DISTRICT COUNCIL
NORTH OXFORDSHIRE

Our Ref: 13/00321/OUT

Application under the Town and Country Planning Act 1990 for the following: OUTLINE - 1000 dwellings together with a local centre including retail (A1), financial services (A2), restaurants (A3-A5), up to a combined total floorspace of 1000m², employment space (B1) up to a total floorspace of 5000m² with the B1(a) office component limited to a maximum of 2,500m², associated car parking, a community primary school (including space for community uses (D1) and assembly and leisure uses (D2)), green infrastructure including formal and informal open space, amenity space, retained hedgerows, structural landscaping, supporting infrastructure (including gas, electricity, sewerage, water, telecommunications), sustainable urban drainage systems, new connection to the A361 Bloxham Road, pedestrian and cycling connections to the surrounding footpath and cycle network and any necessary demolition and ground remodelling

REQUIREMENTS UNDER REGULATION 22 (1) OF THE TOWN AND COUNTRY PLANNING (ENVIRONMENTAL IMPACT ASSESSMENT) REGULATIONS 2011 TO PROVIDE FURTHER INFORMATION IN RESPECT OF THE ENVIRONMENTAL STATEMENT

Figure 38 : Plan showing distribution potential archaeological features detected

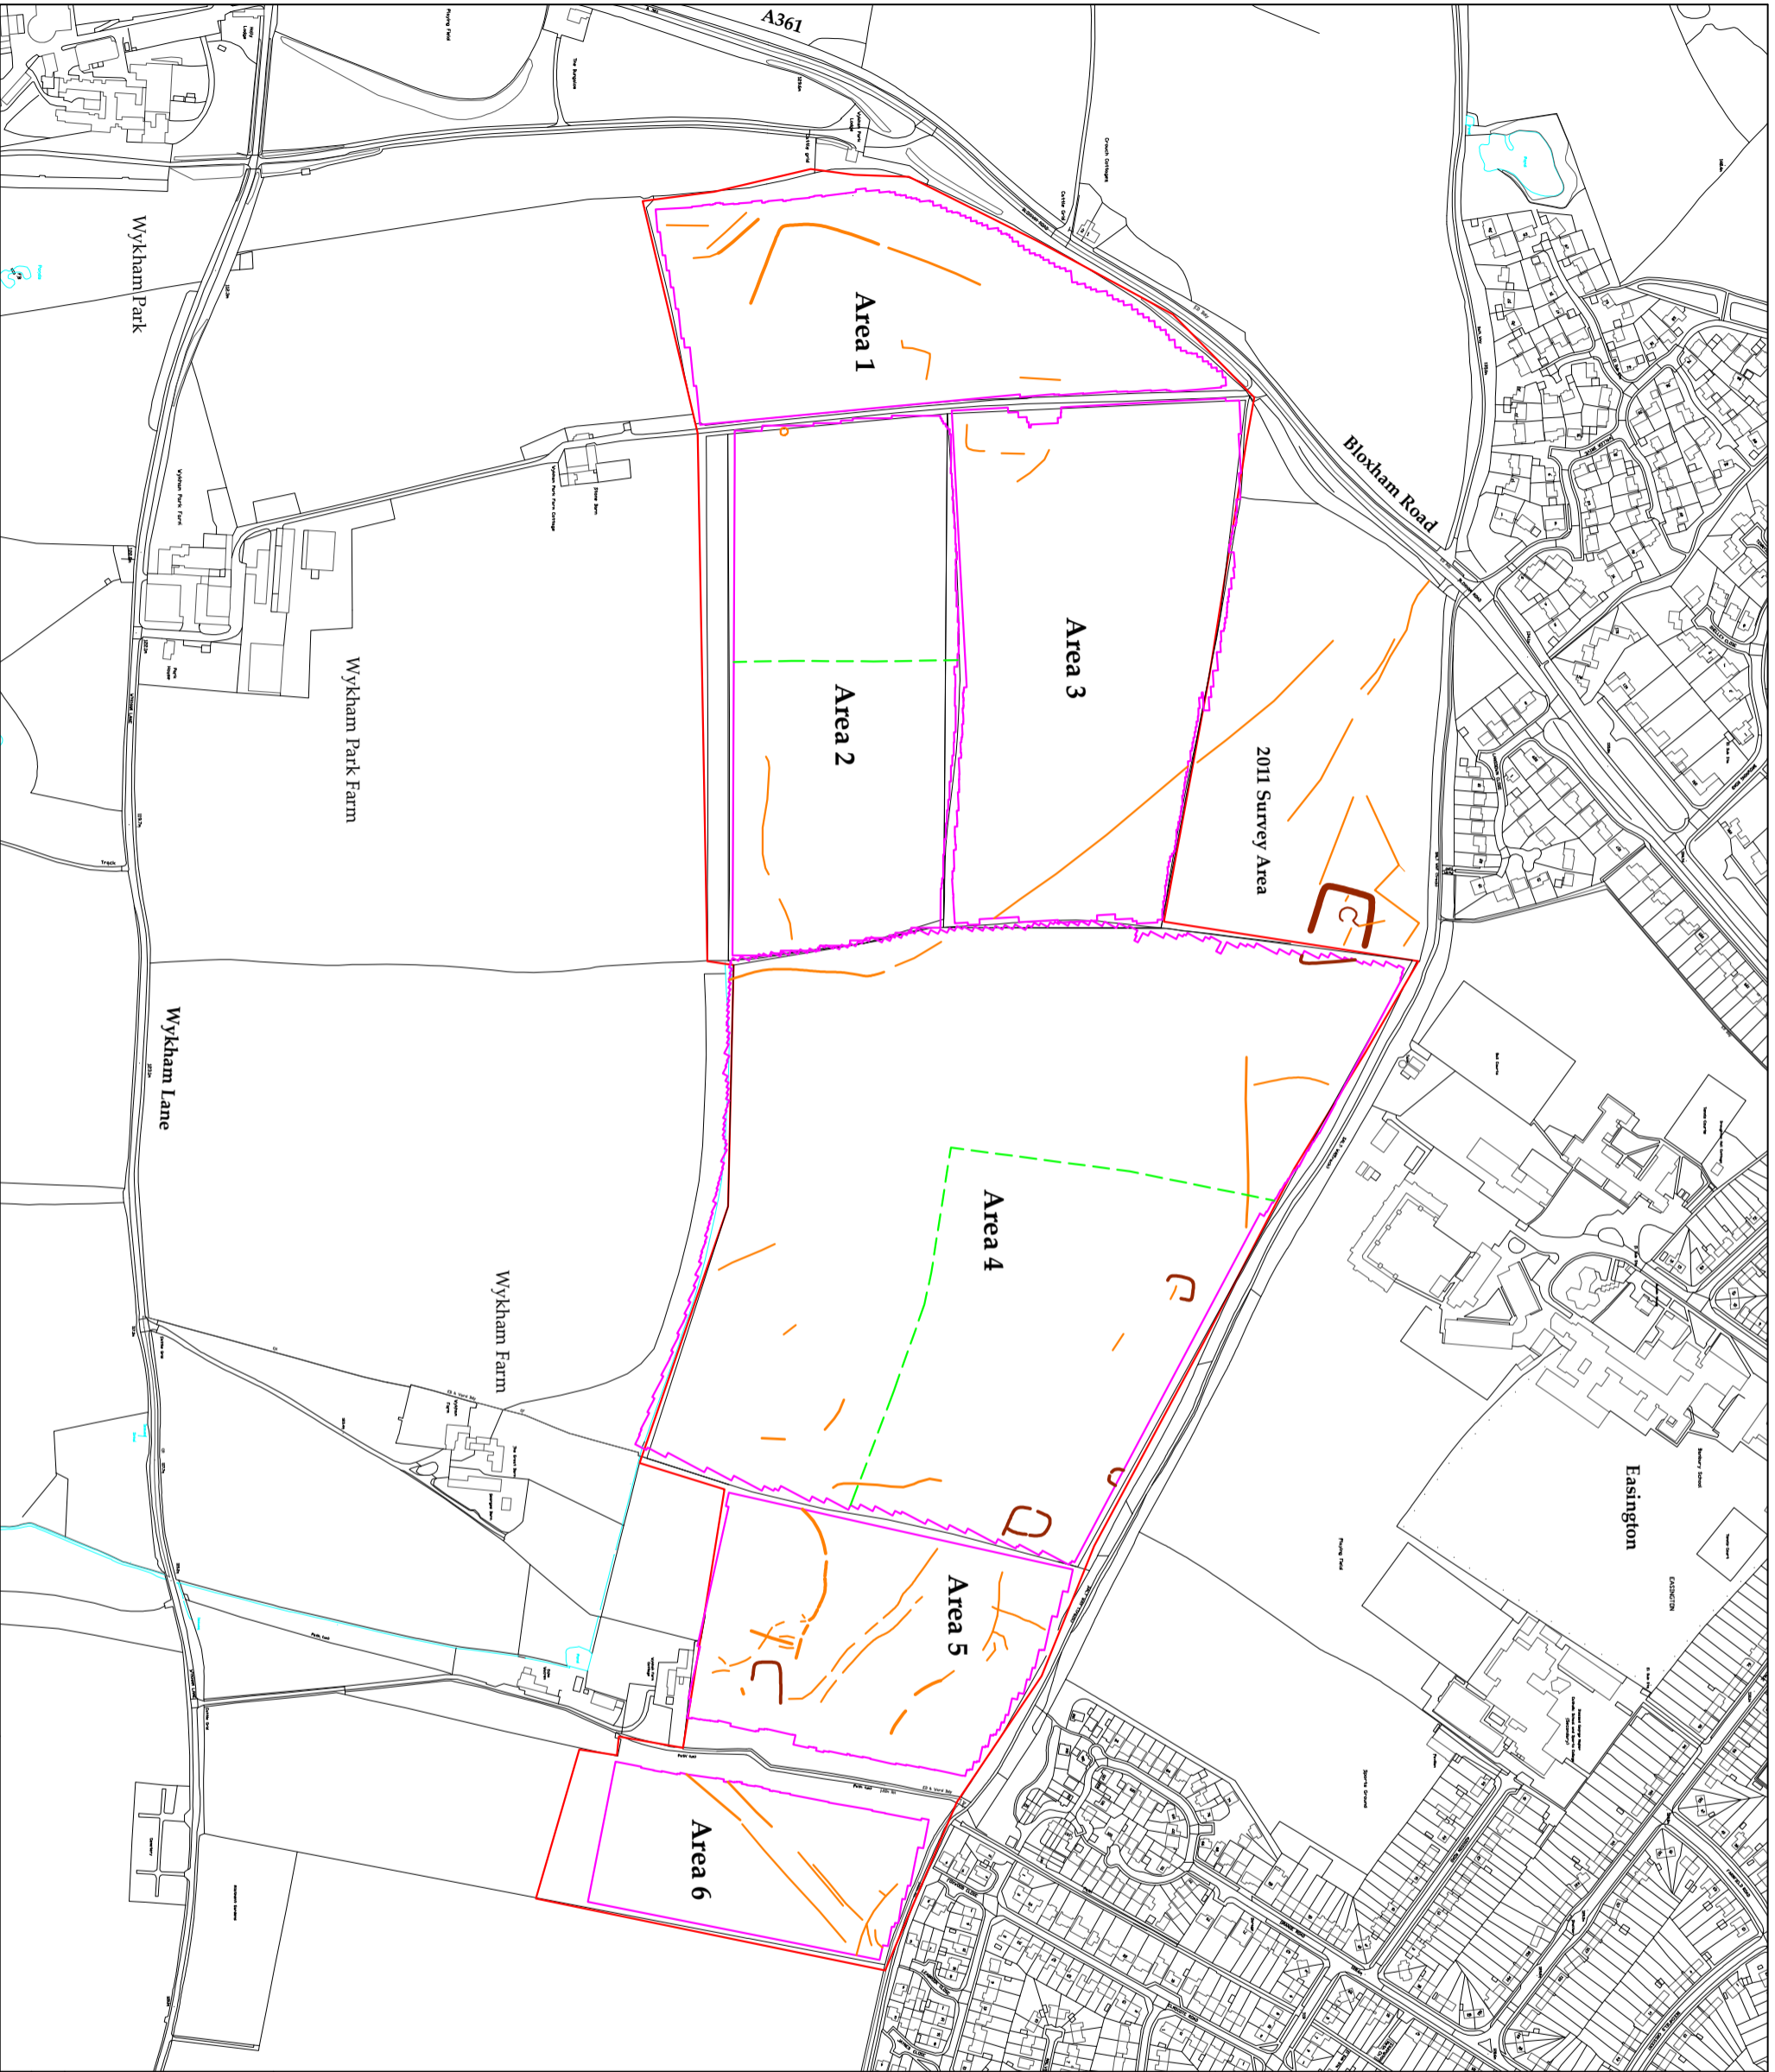
- 8.1.1. The geophysical survey identified a number of probable archaeological features on the site. Therefore, prior to the determination of this application the applicant should be responsible for the implementation of an archaeological field evaluation. This must be carried out by a professionally qualified archaeological organisation and should aim to define the character and extent of the archaeological remains within the application area, and thus indicate the weight which should be attached to their preservation. This information can be used for identifying potential options for minimising or avoiding damage to the archaeology and on this basis, an informed and reasonable decision can be taken.
